**Consultation Response from KC,
Highways Development Management**

2026/91733 Huddersfield Open Market, Brook Street, HD1 1RY

Discharge of details reserved by conditions 7 (crime prevention measures), 8 (Remediation Strategy), 15 (CNEMP) and 21 (CEMP) on previous permission 2025/92443 for external works to Market Building and wider site including alteration and demolition of modern additions to the Market building, new glazed screens, new WC and welfare facilities, provision of services and lighting including associated works, remodelling to the stone annexe, alterations to catering facilities, and self-contained commercial units, works to floor surfaces of Market Building. Use of Market Building for a mix of uses (sui generis) including retail, hot food takeaway, drinking establishment, restaurant / café uses, market office, public welfare facilities, storage facilities as well as provision of areas that provide a mix of fixed and flexible indoor and outdoor market stalls. Creation of areas for open market, siting of associated structures, installation of new fixed market stalls demolition of external bin store and creation of waste compound area, storage compounds, vehicular pa

## Phase 1– Temporary Market Stalls

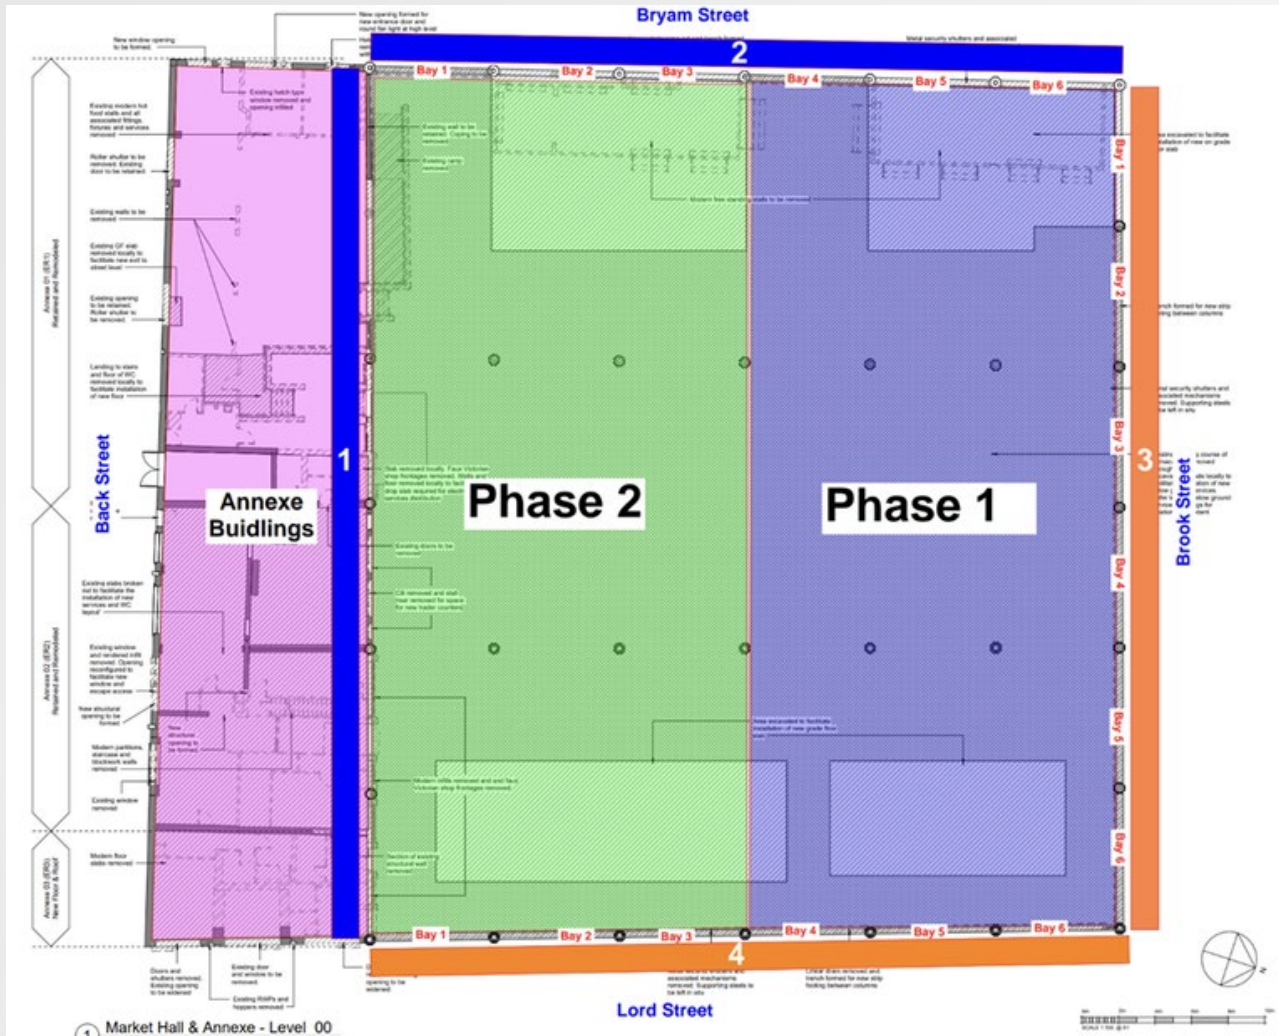
This is indicated on a drawing in the CEMP and is within the gated compound and this is acceptable.

These are shown on the included route plans and are to be located on the site of the existing car park and this is acceptable.

Routes towards site.

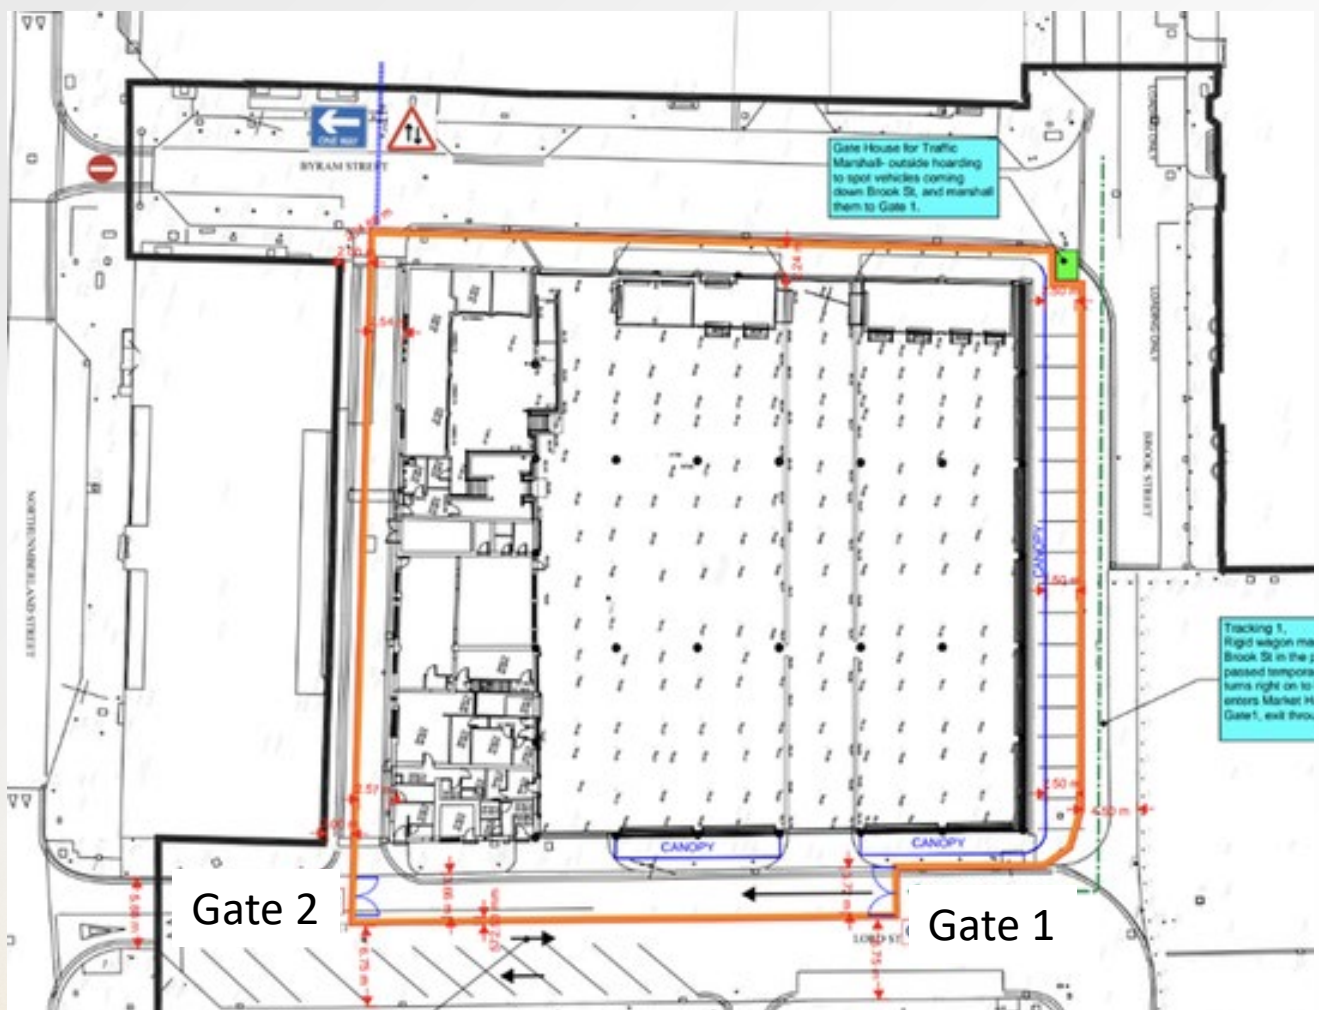
These routes are clearly shown on ariel photographs within the CEMP and are suitable for construction vehicles and as such are acceptable.

It should be noted, however, that there is currently roadworks at the junction of A62 Castlegate and St John's Road and some movements are not available from Castlegate and so the access may need to be temporarily re-routed via either Fitzwilliam Street or Viaduct Street.

Deliveries are to be managed via a booking system and will access the site via Brook Street with the delivery vehicles being escorted through the site to ensure the safety of market users. This is acceptable.
